## Appendix A Response to Government and Agency Submissions

The following is a response to the full text of submissions provided by or on behalf of State and local government agencies. For completeness, the full text of each submission is provided in the left-hand column, accompanied by the proponent's corresponding response in the right-hand column. The proponent's responses have been informed by input by the expert consultant team, and should be read in conjunction with the publicly exhibited Environmental Impact Statement and accompanying technical reports, as well as the Response to Submissions Report to which this document is appended.

Issue	Response
<b>1. Department of Planning and Environment</b>	
<b>Floor Space Ratio (FSR)/Gross Floor Area (GFA)</b>	
The Department considers the appropriateness of the proposed GFA to be closely linked with how the proposal addresses a range of key issues including future built form, setbacks, open space, deep soil planting, biodiversity/tree removal, overshadowing/solar access and traffic generation.	Refer to the responses below.
The Department has set out how each of these particular issues need to be addressed below. Additionally:	
<ul

2.5 IMPROVED RELATIONSHIP TO 137-143 HERRING ROAD

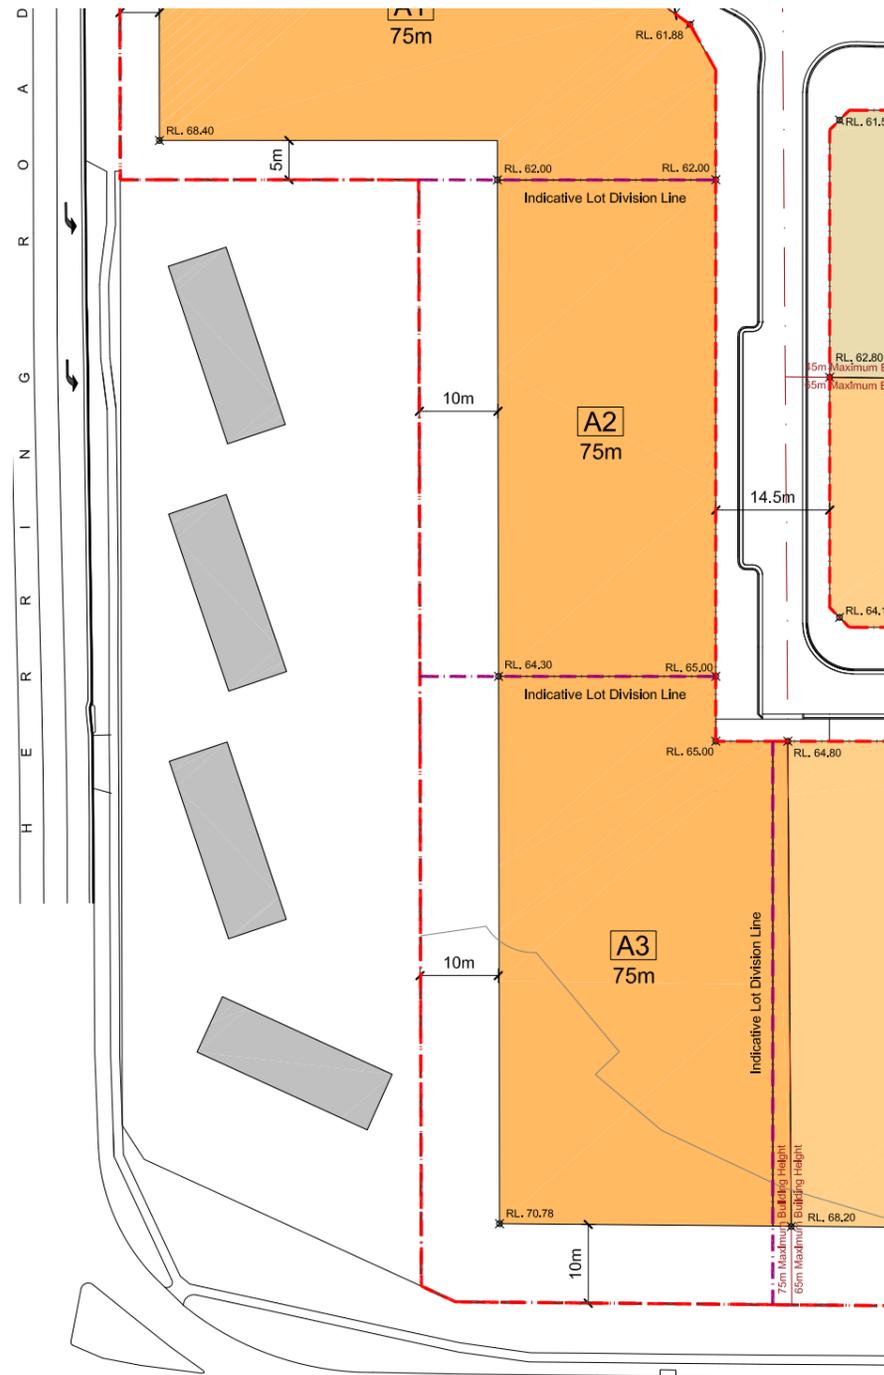
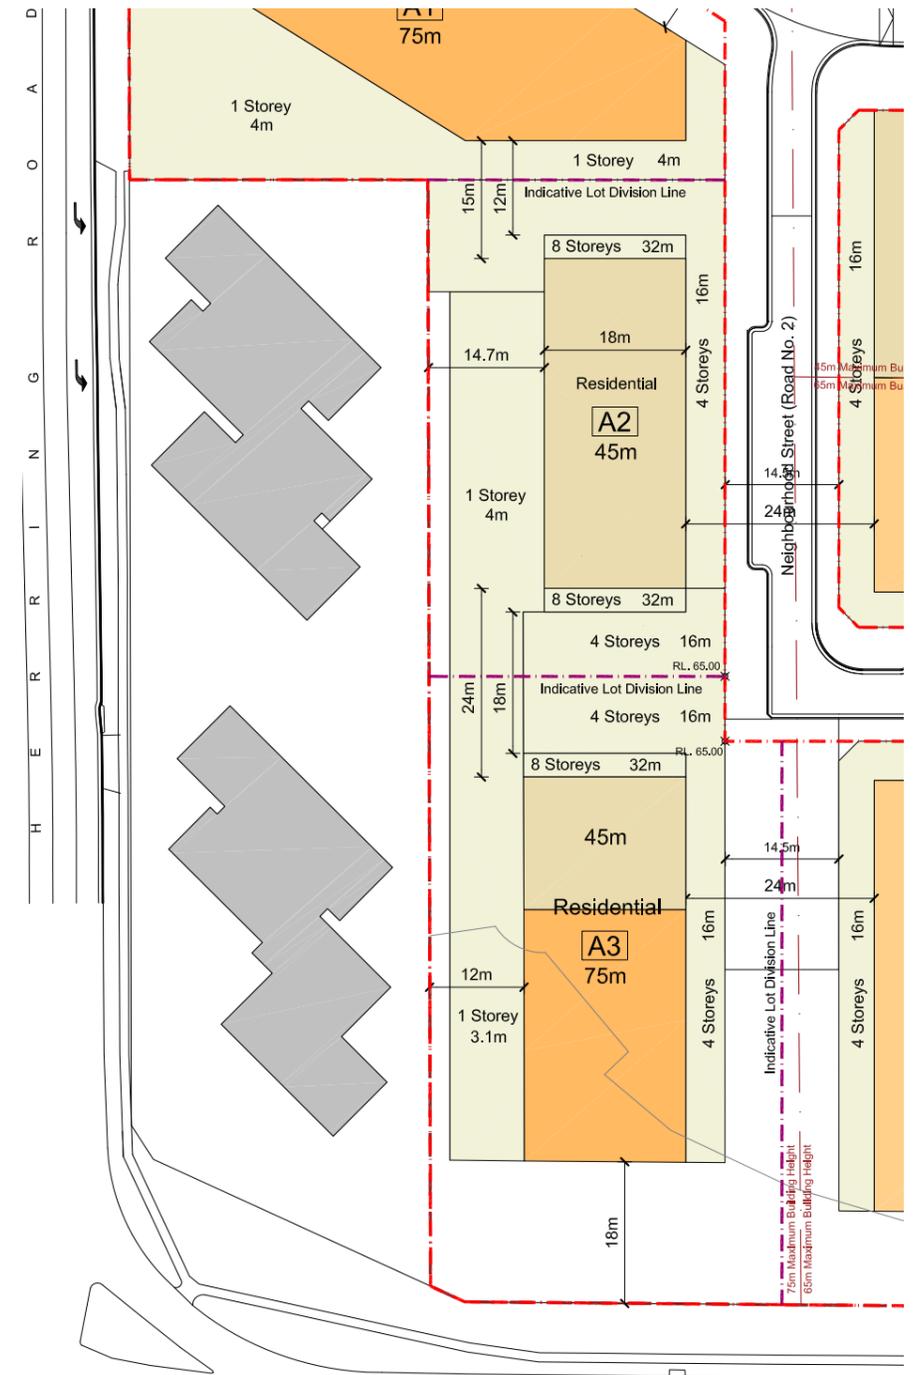
Issue	Response
<ul style="list-style-type: none"> <li>Provide further consideration of the proposed development in relation to the approved redevelopment at 137-143 Herring Road. This should be accompanied by revised drawings, shadow diagrams and relevant Apartment Design Guide (ADG) analysis including building separation and solar access to both the subject site and the approved development at 137-143 Herring Road.</li> </ul>	<p>The Masterplan has been updated to consider the approved development at 137-143 Herring Road. This includes:</p> <ul style="list-style-type: none"> <li>Provision of maximum separation distance recommended by the ADG.</li> <li>Updated shadow diagrams and solar access analysis.</li> <li>Incorporation of design guidance to maintain privacy in the Ivanhoe Masterplan Design Guidelines.</li> </ul>
<ul style="list-style-type: none"> <li>Provide further consideration of the proposed development in relation to the likely future form/scale of development on sites to the north-east (Peach Tree Road) i.e. building separation, solar access, privacy.</li> </ul>	<p>The revised Masterplan has considered the relationship to existing and future development on Peach Tree Road in the following ways:</p> <ul style="list-style-type: none"> <li>Setbacks and building separation are provided in accordance with the requirements of the ADG or the RDCP.</li> <li>Visual privacy will be maintained through the provision of adequate separation distance and future detailed design measures.</li> </ul> <p>Adjoining properties on Peach Tree Road are located north of the site and, as a result, development subsequent to the Masterplan will not cast shadow on the properties on Peach Tree Road.</p>

DCP REQUIREMENT - 5M SETBACK

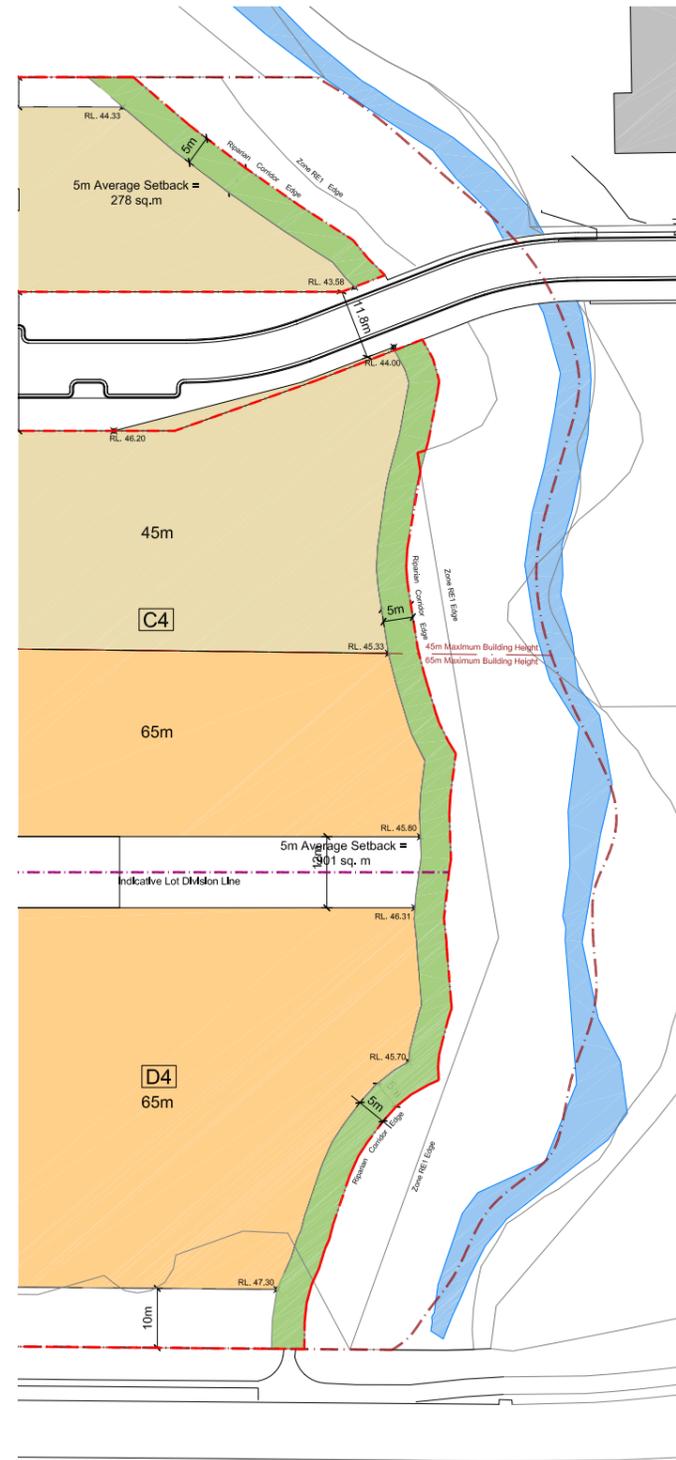
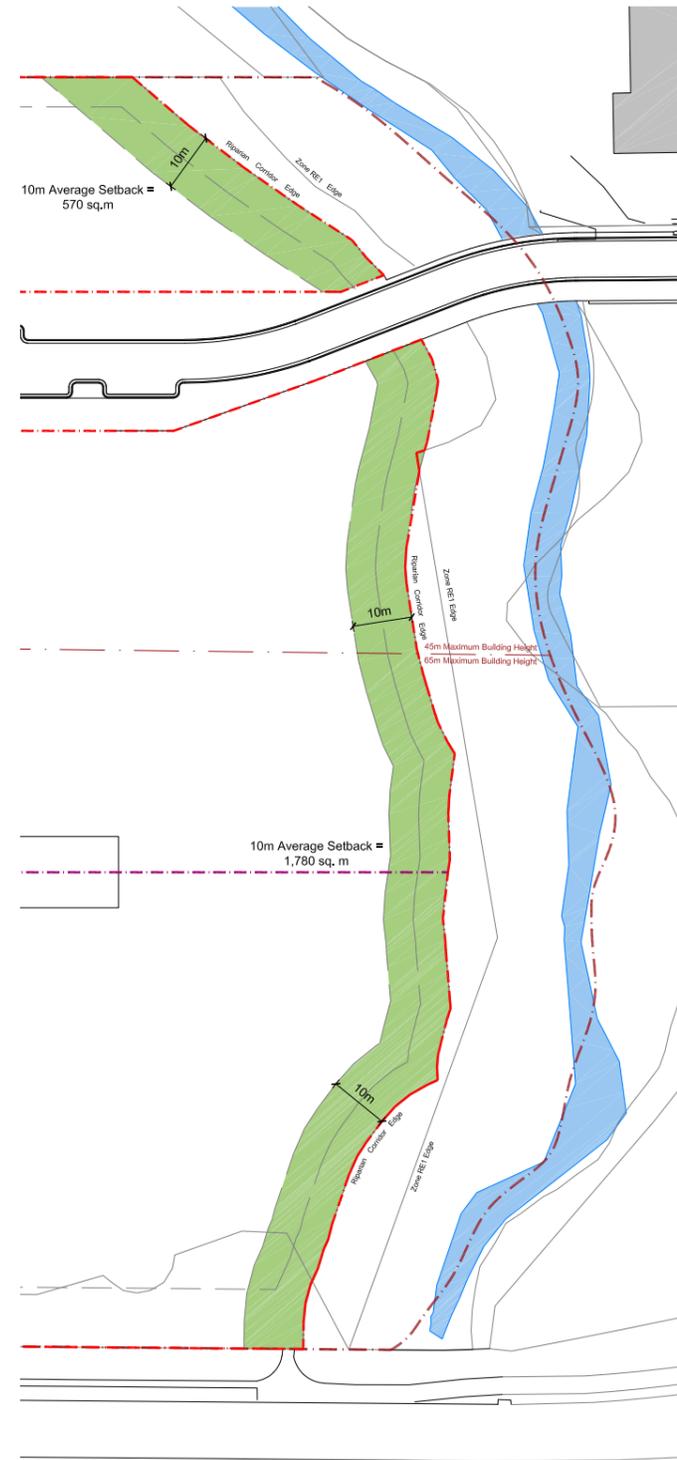
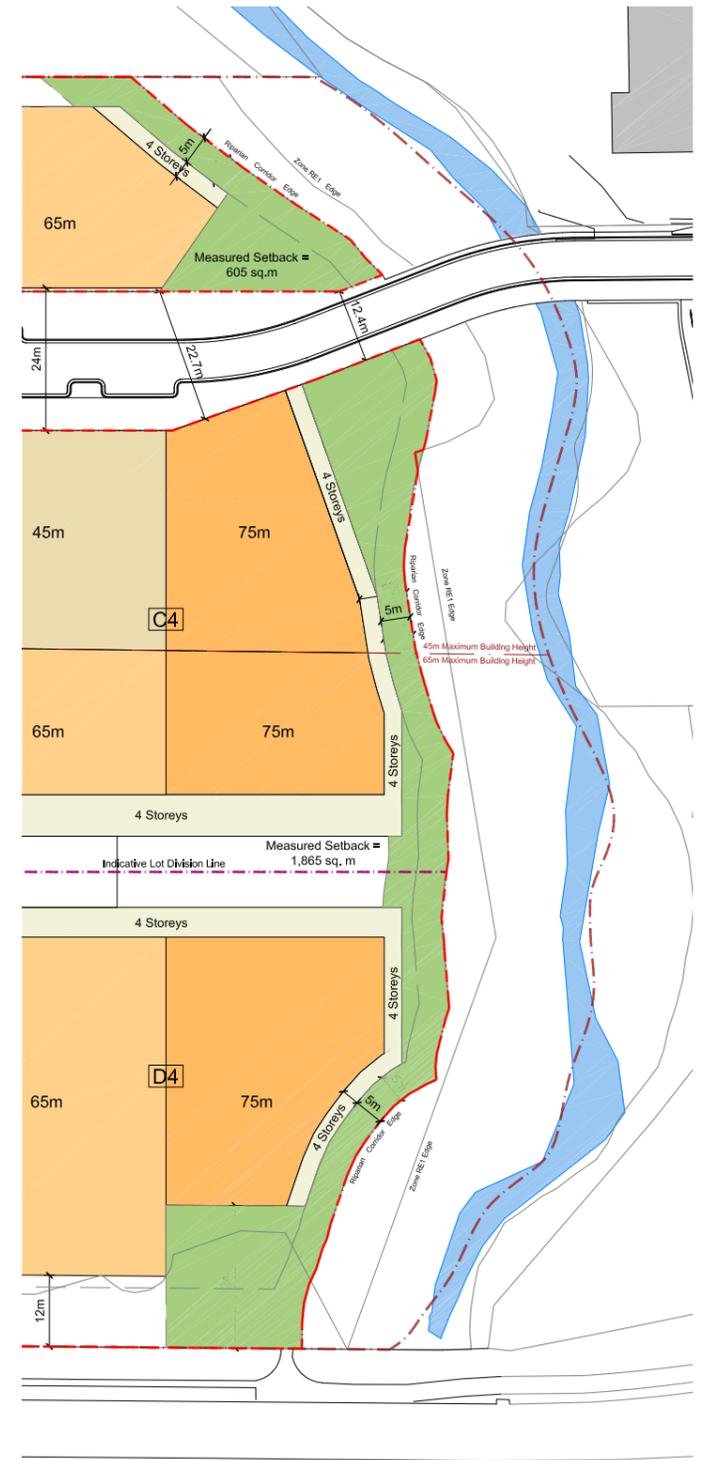
<ul style="list-style-type: none"> <li>Provide further information and consideration of the proposed setbacks/buffer zone from the edge of the 20 m wide Shrimptons Creek riparian zone.</li> </ul>	<p>The refined Masterplan has provided an increased setback to the Shrimptons Creek riparian zone, resulting in the provision of additional green space around the riparian corridor and an improved buffer zone. This is discussed in further detail in the Response to Submissions report.</p>
<ul style="list-style-type: none"> <li>Provide further consideration of proposed future building forms (facade length, upper and lower level setbacks), particularly in relation to public domain areas including Shrimptons Creek.</li> </ul>	<p>The updated Ivanhoe Masterplan Design Guidelines include specific provisions for the built form adjoining public domain areas and Shrimptons Creek to ensure that future buildings complement the public domain and create a pedestrian-scale environment.</p>

viii. Building C4/D4 with respect to the Creek: No clear dimensions have been shown on the envelope control plan to indicate the actual width of land along the creek. A survey plan needs to establish these dimensions with respect to the edge of the creek. If the edge of riparian zone as shown on the plan is taken to be accurate then a clear 10m setback for the buildings are required as a natural buffer from the riparian zone in accordance with Urban Design Guide for Ivanhoe Estate Redevelopment. This will also assist with a reasonable and meaningful separation of the built form and basement from the open space on the edge of the Creek.	The Envelope Control Plan has been prepared based on the survey undertaken for the site by ADW Johnson. A 5 metre setback at lower levels from the edge of the riparian corridor to the building envelopes is provided in accordance with the setbacks stipulated in the RDCP, however on average along the entire Shrimpton's creek frontage a 10m setback has been achieved with varying areas of open space.
